An
Coimisiún
Pleanála

Inspector's Report ABP-321454-24

Proposed development of 10 Wind Turbines, 110kV Electrical Substation and ancillary development within the townlands of Brittas, Rossestown, Clobanna, Brownstown, Killeenleigh, Kilkillahara, Brittasroad, Coolgarrane, Athinid More, Cassestown, Laghtagalla, Farranreigh, Furze, Loughlahan, Ballygammane, County Tipperary.

Brittas Wind Energy Limited

Figure 2-7: Proposed layout of Wind Farm Infrastructure within the Planning Application Boundary

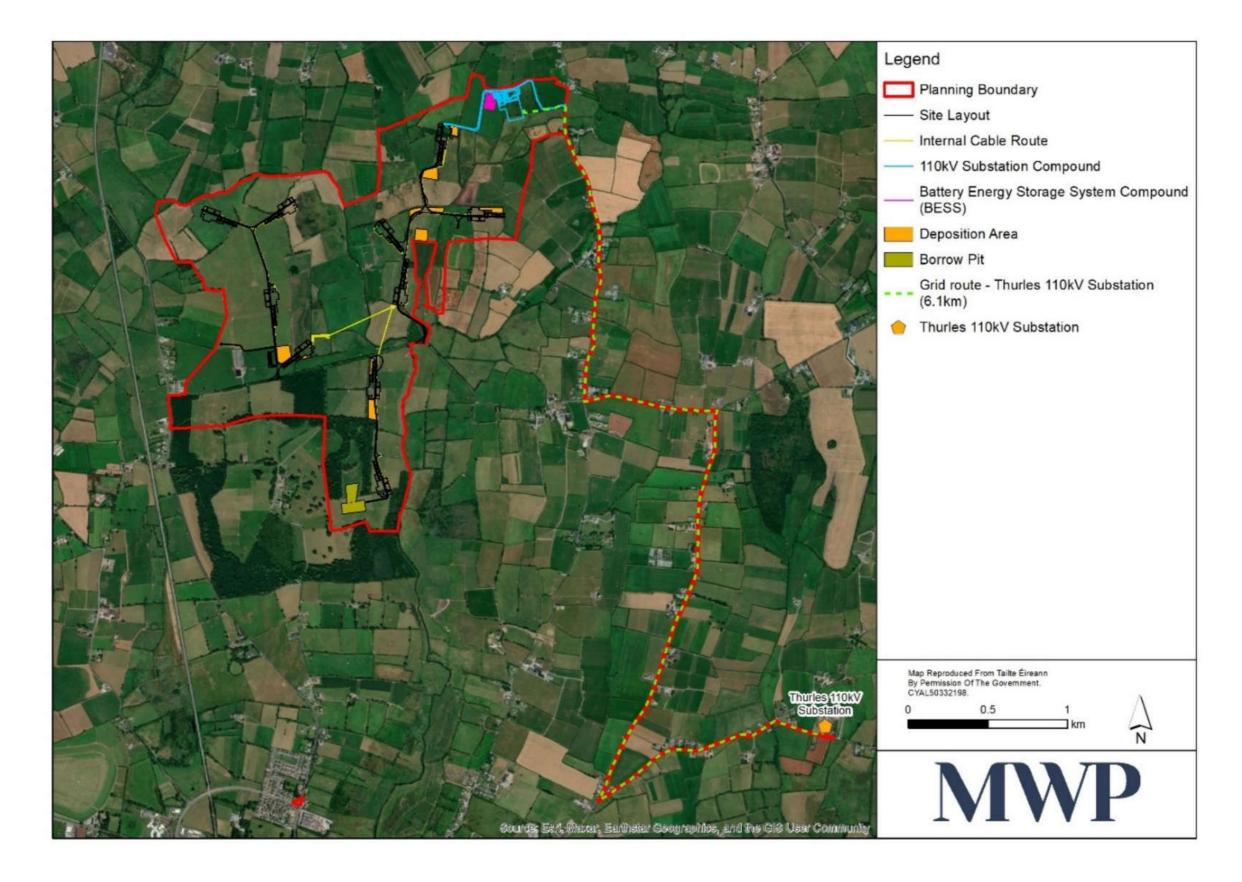
- The Grid Connection Route which is detailed in Figure 2-7 indicates that there are no interactions with the existing strategic national road network. However, Section 12.5.1 of the Tipperary County Development Plan 2022-2028 identifies the Thurles Bypass Scheme as a Strategic Roads Investment Project. In accordance with official policy outlined in Section 2.9 of the DoECLG Spatial Planning and National Project Guidelines for Planning Authorities, proposed national road schemes should be protected and kept free from development impacts that could compromise their delivery. TII recommends consultation with Tipperary County Council Roads Design Office

in considering this application to address and resolve any impacts to the national roads scheme.
